From: Anita Gardner <Anita.Gardner@arun.gov.uk>
Sent: 13 January 2021 17:10
To: Planning.Responses <Planning.Responses@arun.gov.uk>
Subject: FW: Croft Works Site Access Driveway

From: Ian Stocks [REDACTED] On Behalf Of FRS Water and Access
Sent: 13 January 2021 17:05
To: Anita Gardner <Anita.Gardner@arun.gov.uk>
Cc: Stephen Garrard [REDACTED]
Subject: RE: Croft Works Site Access Driveway

Subject: Croft Works Site Access Driveway

Drawing Title
Location Plan and Site Plan

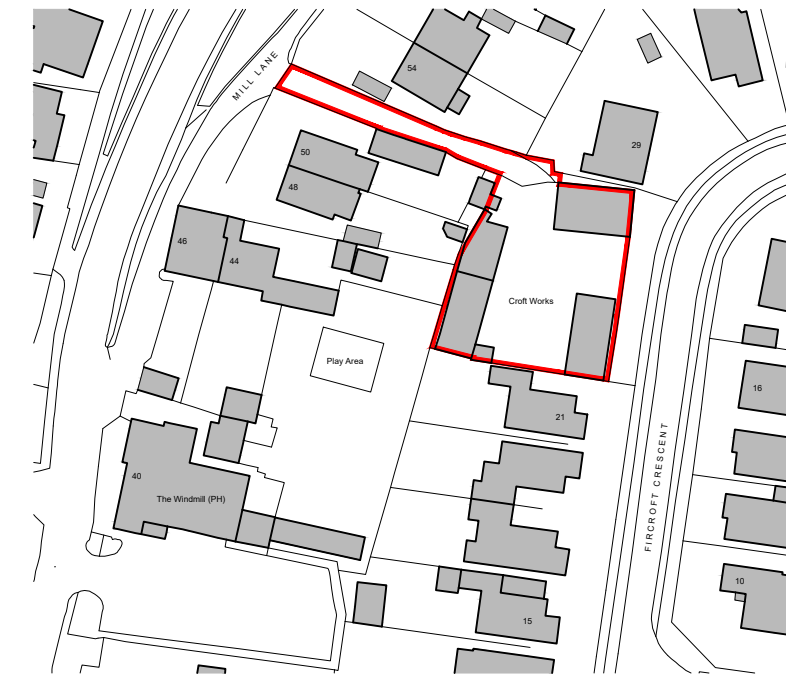
Having viewed the plan attached and read the e-mail below, the current intensions do not meet with the requirements of Approved Document – B Volume 1: 2019 edition B5 section 13 for Fire Appliance access. The minimum access width for a fire appliance is 3.7 metres between curbs and 3.1 metres through a gateway in a straight line, so there is adequate access width, would then need suitable space to turn and make an exit, which may also be possible.

However for houses fully sprinklered in accordance with British Standard (BS) 9251: 2014 or BS EN 12845, BS 9991:2015 para 50.1.2 does allow the distance between the fire appliance and any point within all houses to be up to 90 metres. The distance from the main road to the furthest point is approximately 80 metres so within this required distance. This does however put additional stress on the fire crews attending as all equipment required will need to be carried to and from the site.

If access to the properties is not suitable for a fire appliance there is no reason to have a fire hydrant along the access driveway. Fire hydrants provide water to the fire appliance not the scene of the fire; there is insufficient water supply pressure from water mains to fight fires, this water then keeps the supply tank full on the fire appliance that feeds a pump that increases the pressure to 25 bar, suitable for firefighting. There is an existing fire hydrant within 30 metres of the access point.

The closer a fire appliance can get to a property the more equipment is directly available to the fire crew and less time is spent setting up equipment for attending a fire. A 50 metre hose connected to the pump on an appliance is run out and used immediately on arrival. If the fire appliance is not within 45 metres of all parts of all dwellings then flat wall hoses then have to be run out, connected and pressurised before a fire can be approached, all of which takes valuable time. So the preference would be to gain access to the properties, if this cannot be achieved each property will need to be fully sprinklered.
